From: Simon Davis
Sent: 25 January 2019 16:12
To: 'Orchard Enterprises' [REDACTED]
Subject: BR/219/18/PL - 9 Westloats Lane

Project Proposed plans and elevations	Sheet
Date 30th April 2018	2
Scale 1 : 100 & 1 : 50

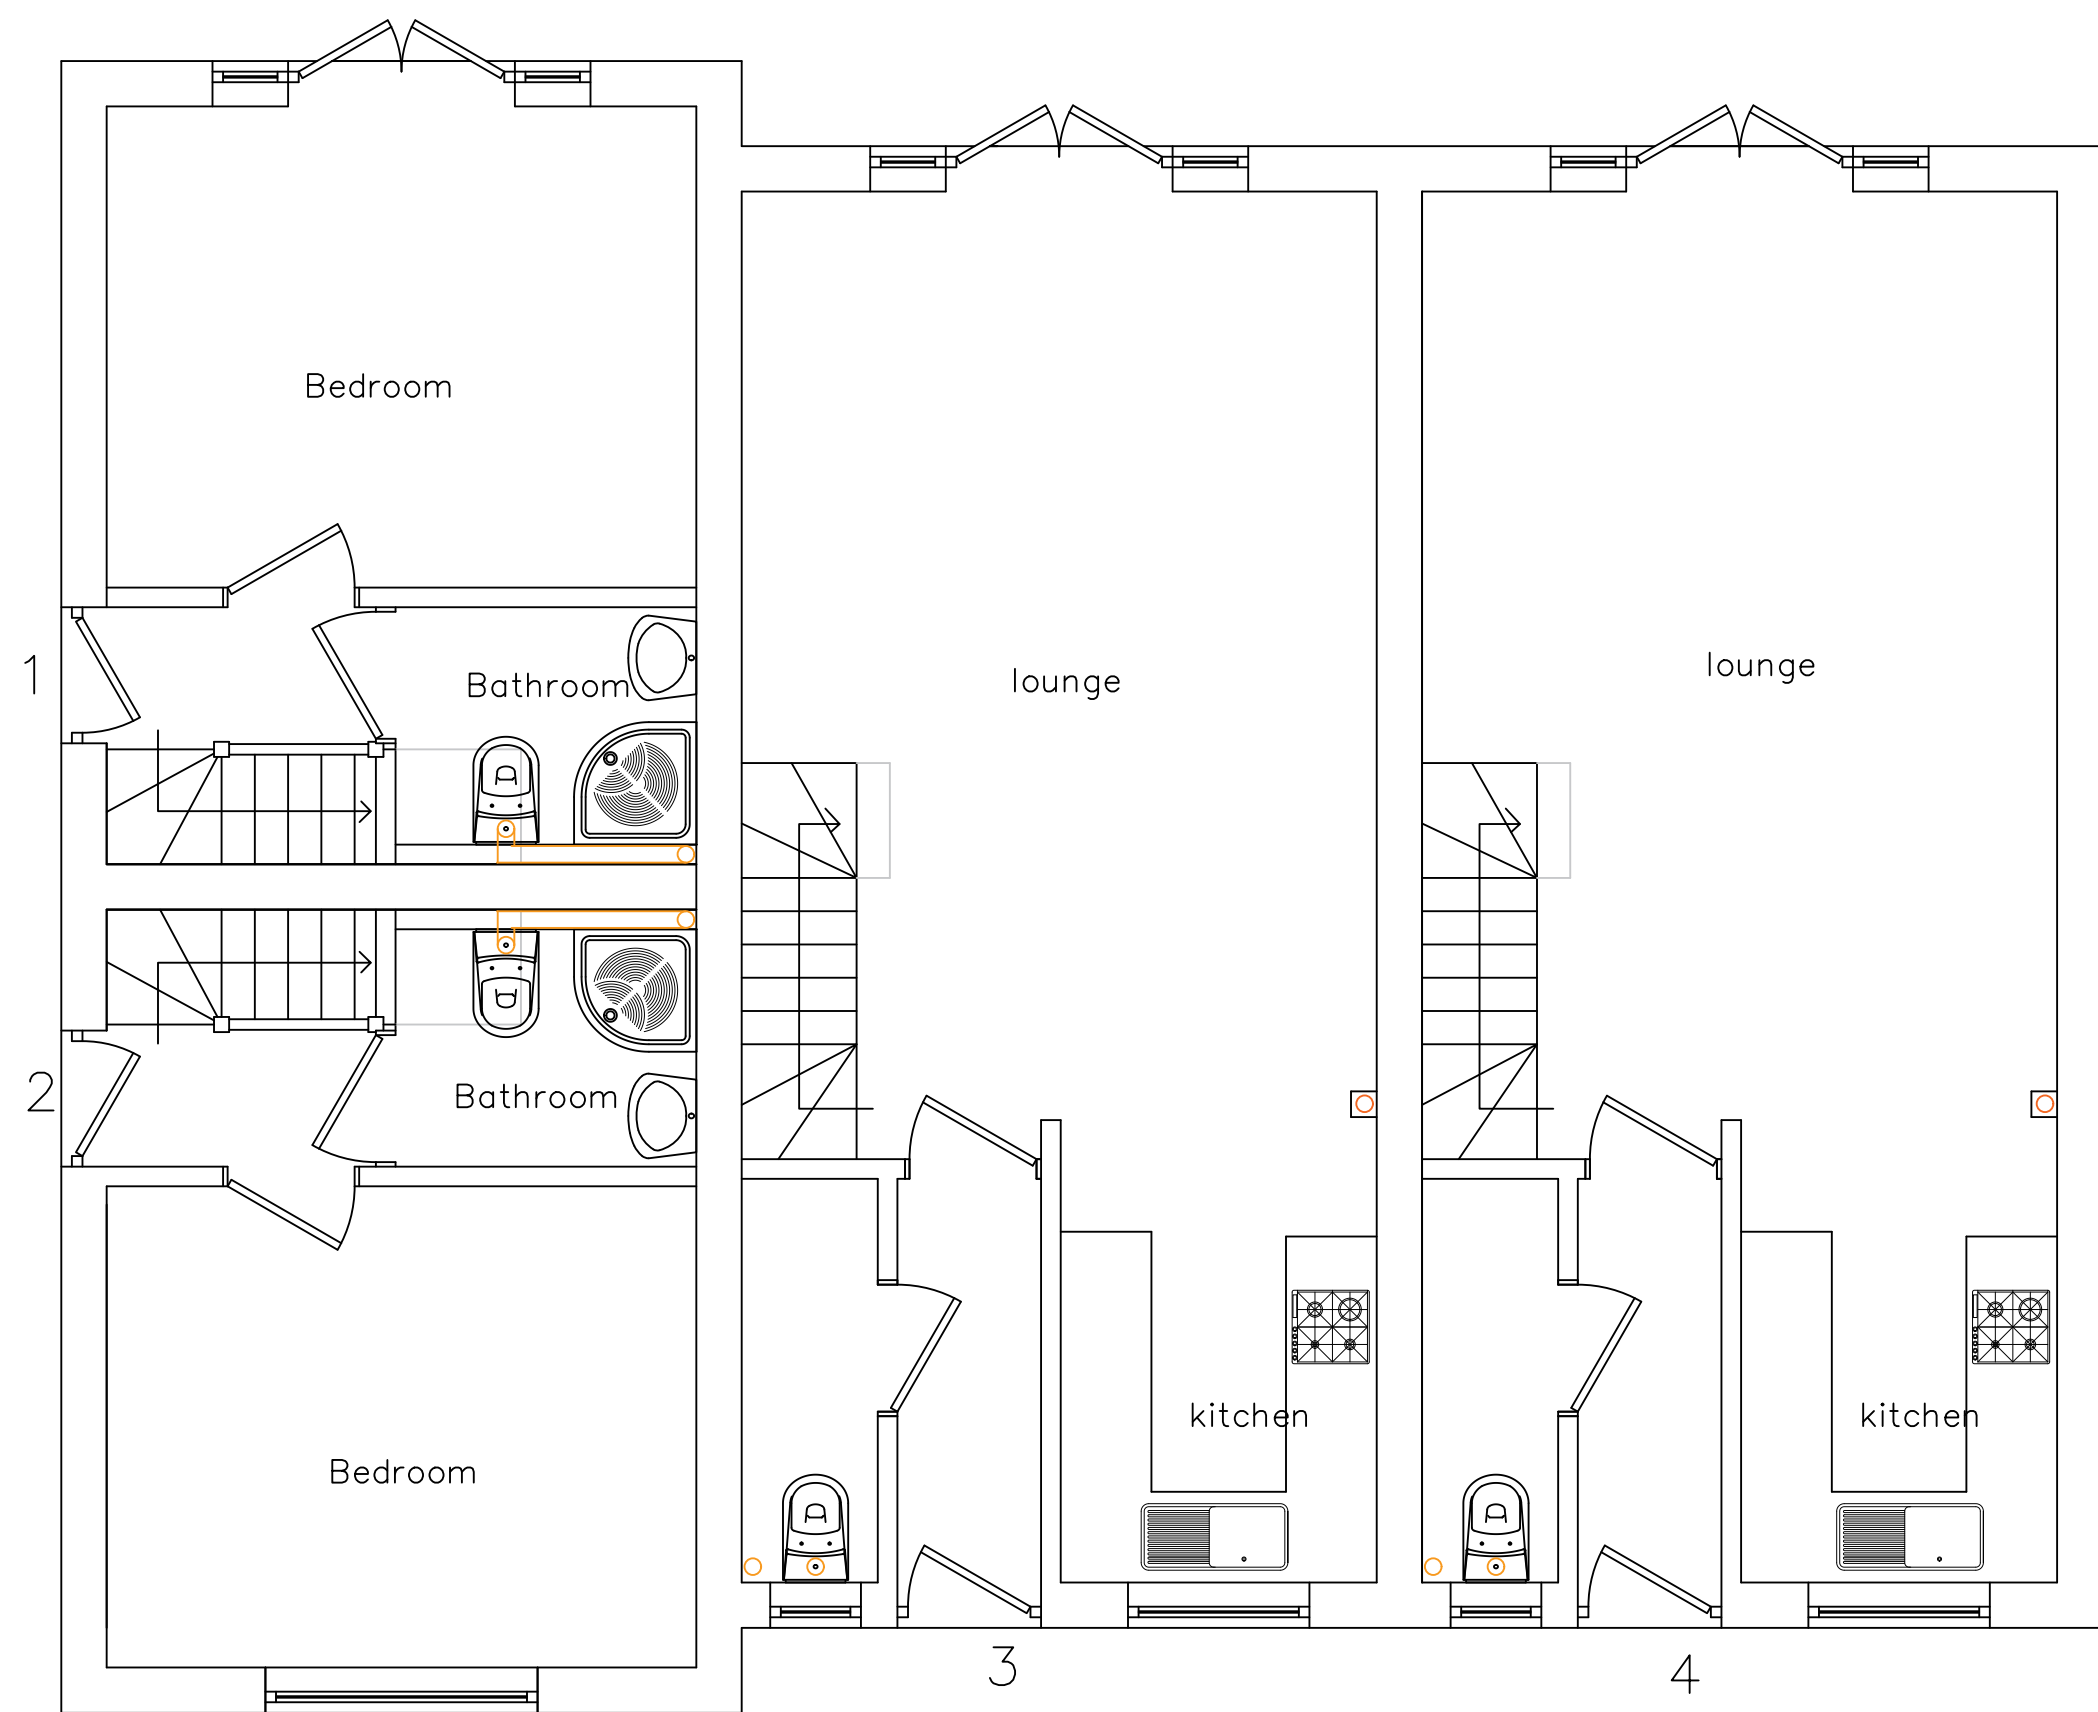
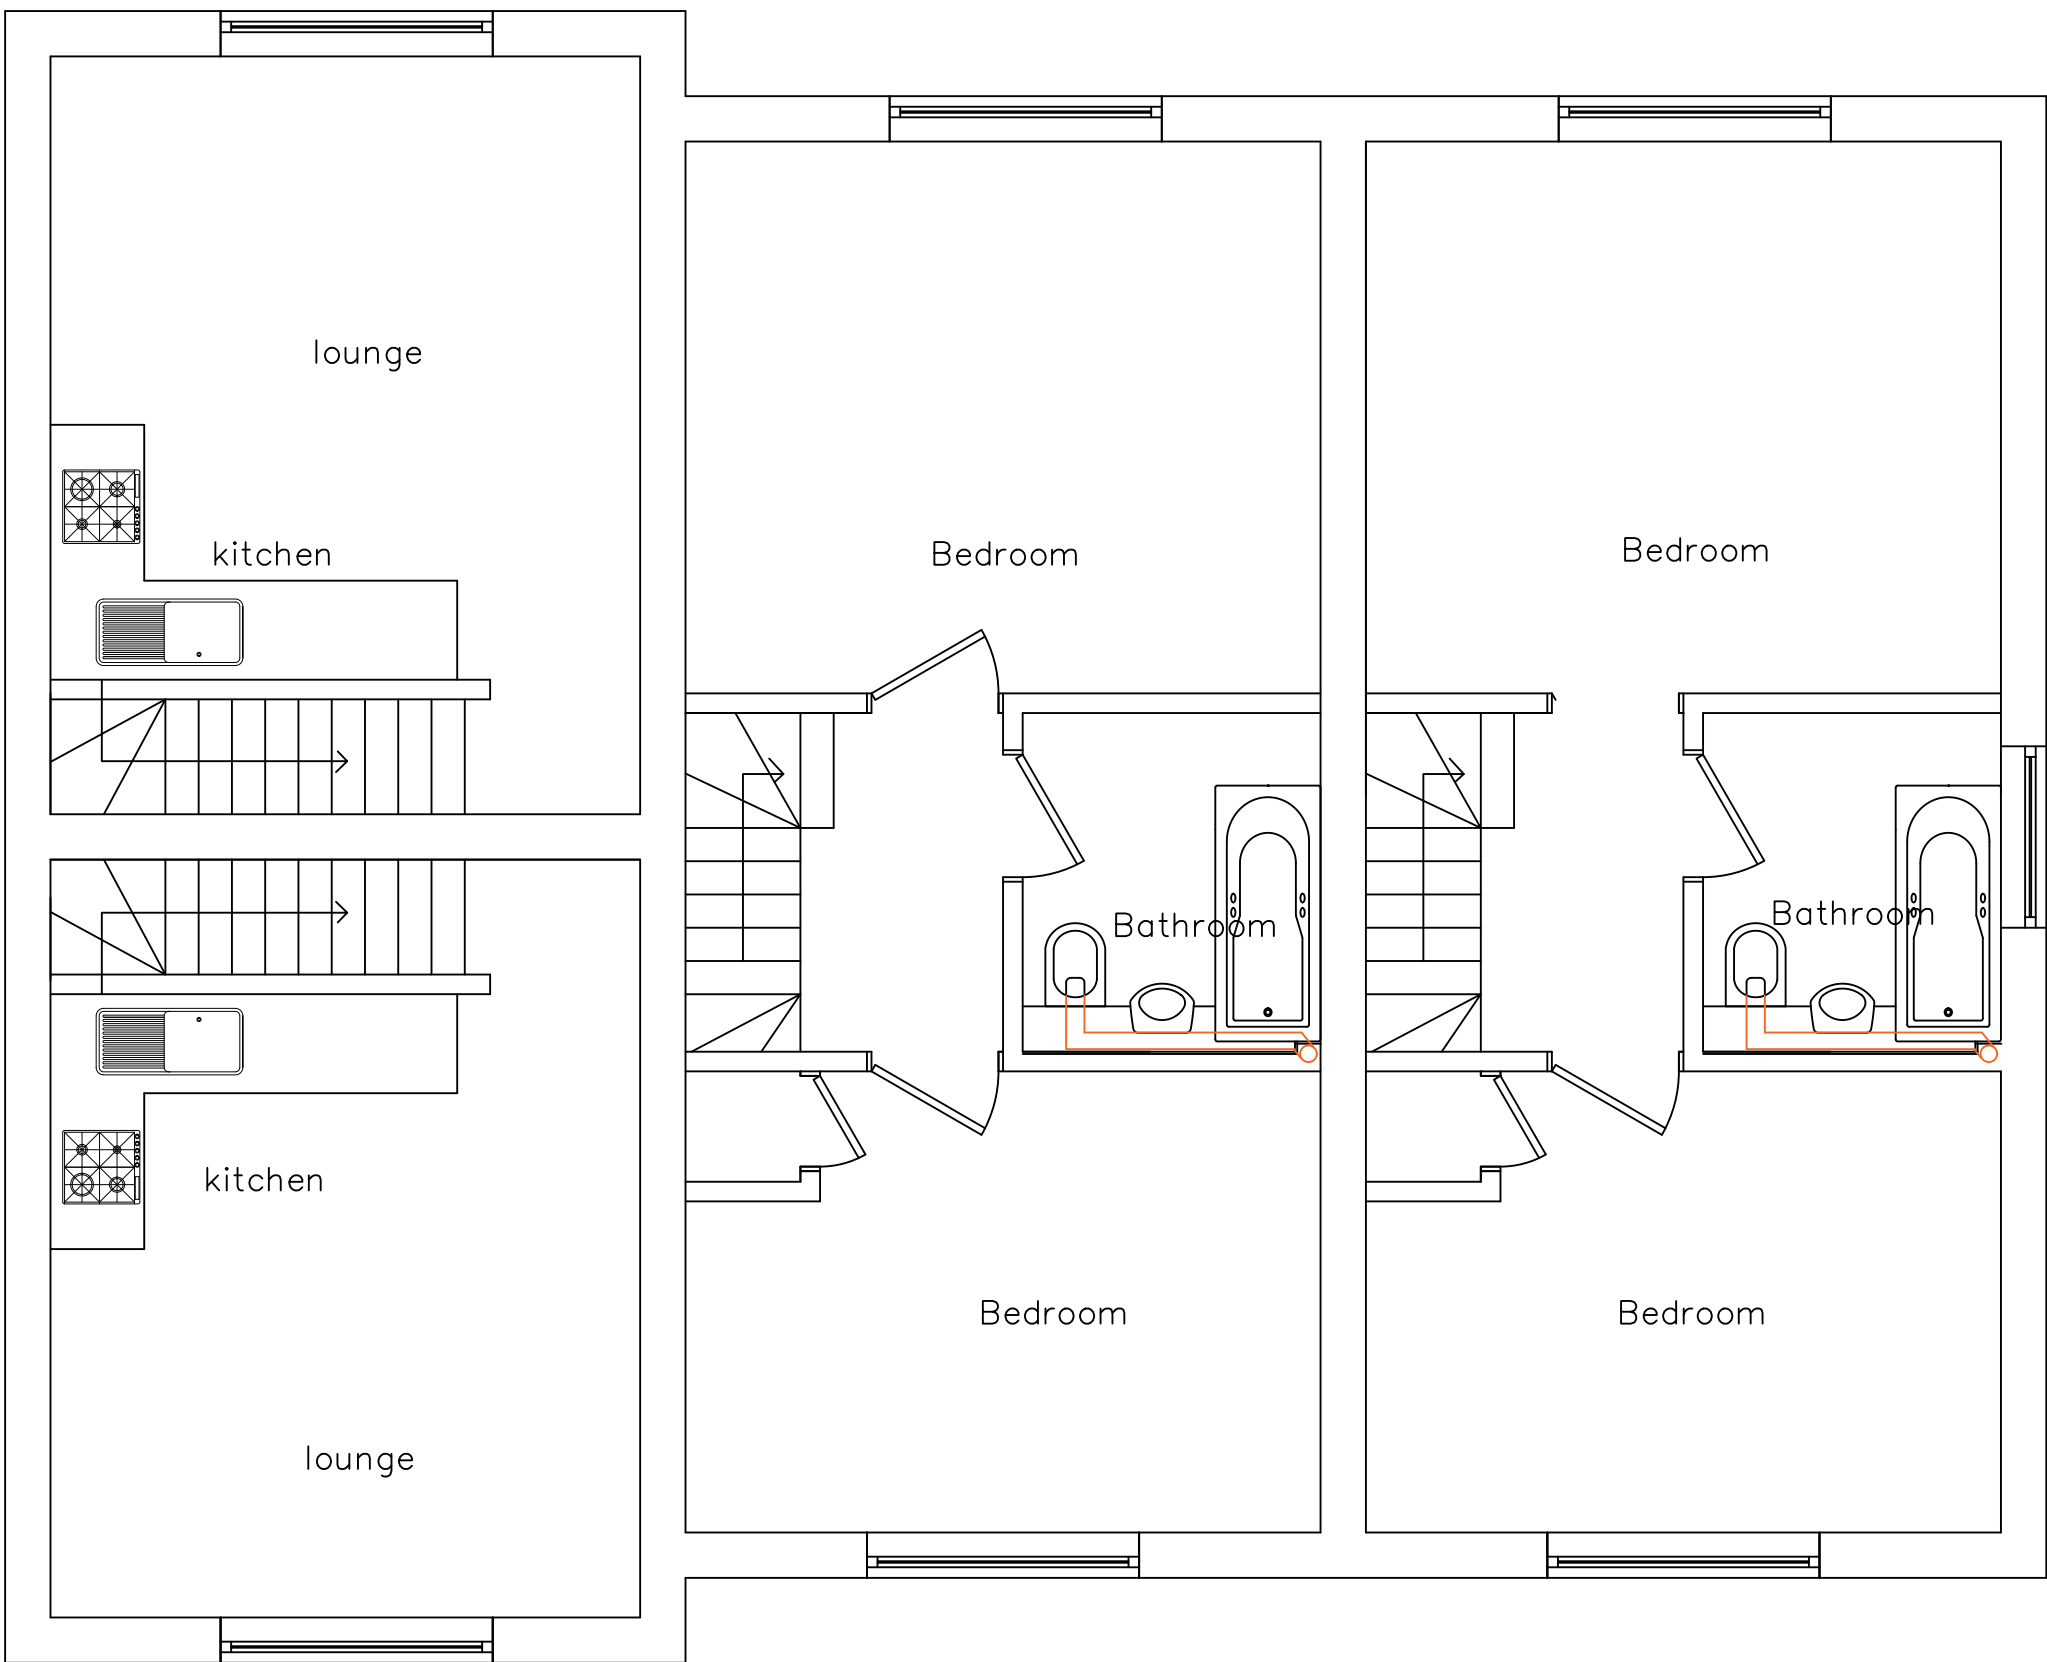
Thanks for your voice message. I am now at the point of being able to work on your decision. I did initially have concerns with the depth of the building and the relationship to no. 10. However, I am aware that no. 10 has no principal windows on the side of its rear closest to your site, also that your site is to the north. Therefore I am going to write this up for approval. I am working on this currently but will not be able to finish until next week will need a further extension of time until Tuesday 5th February.
